Department of Planning and Environment

Each issue raised in the Department's letter is addressed in detail in Section 2 of the Response to Submissions.

Willoughby City Council

Figure 7: Proposed Ground Floor Car Parking Arrangement (source: EIS)

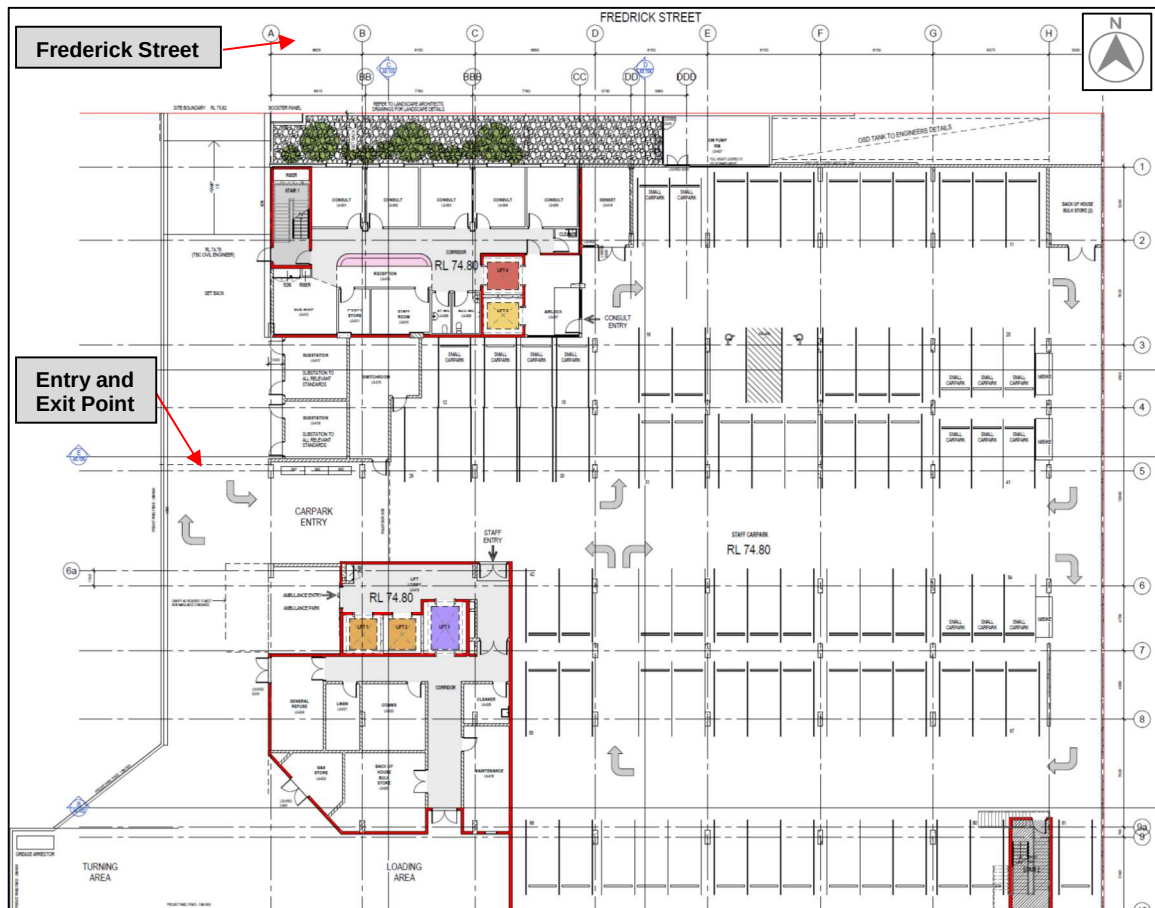
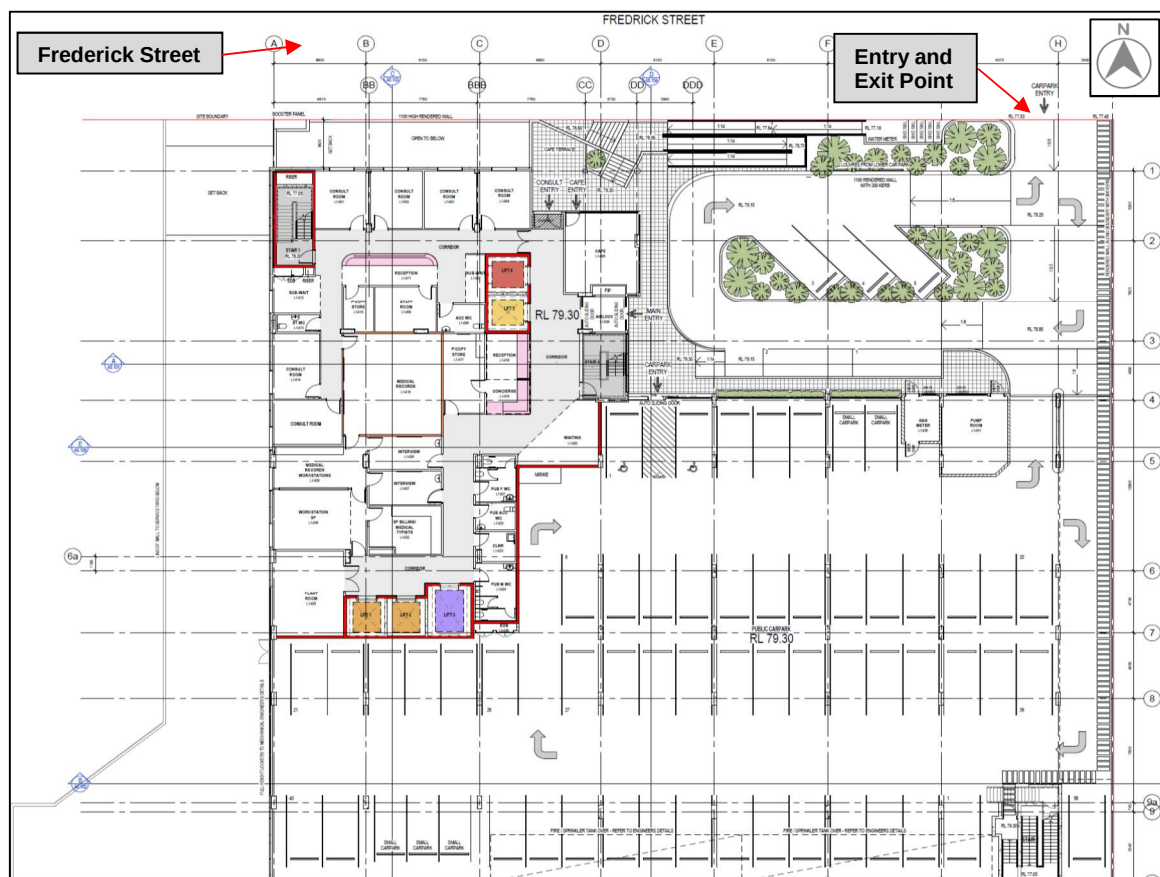
Recommendation/issue	Comment										
1. Statutory and Strategic Context The proposal is consistent with the site specific local provisions of Willoughby LEP 2012.	Noted.										
2. Built form and Urban Design	See Section 2.1 of Response to Submissions										
3. Transport and Accessibility A total of 140 car parking spaces are required. The driveway, car parking layout and loading area are non-compliant with AS2890.1 and AS2890.2.	Car parking requirements as per the DCP are as follows:

The traffic consultant has again reviewed the proposed driveway, car parking layout and layout area and confirmed it is consistent with the applicable standards. (It is noted that Council has not provided any specific non-compliances.) The car parking area will be constructed to the relevant Australian Standards.	Practitioners	30	Staff	46.5	Beds	37.3	Patients	25	Total:	138.8 (139)
Practitioners	30										
Staff	46.5										
Beds	37.3										
Patients	25										
Total:	138.8 (139)										
4. Noise and Vibration A Noise Impact Statement was submitted addressing the relevant provision of WLEP 2012	Noted.										
5. Contamination Phase 1 and 2 Contamination Reports and a Remediation Action Plan were submitted with the EIS.	Noted.										
6. Stormwater	See Section 2.2 of Response to Submissions
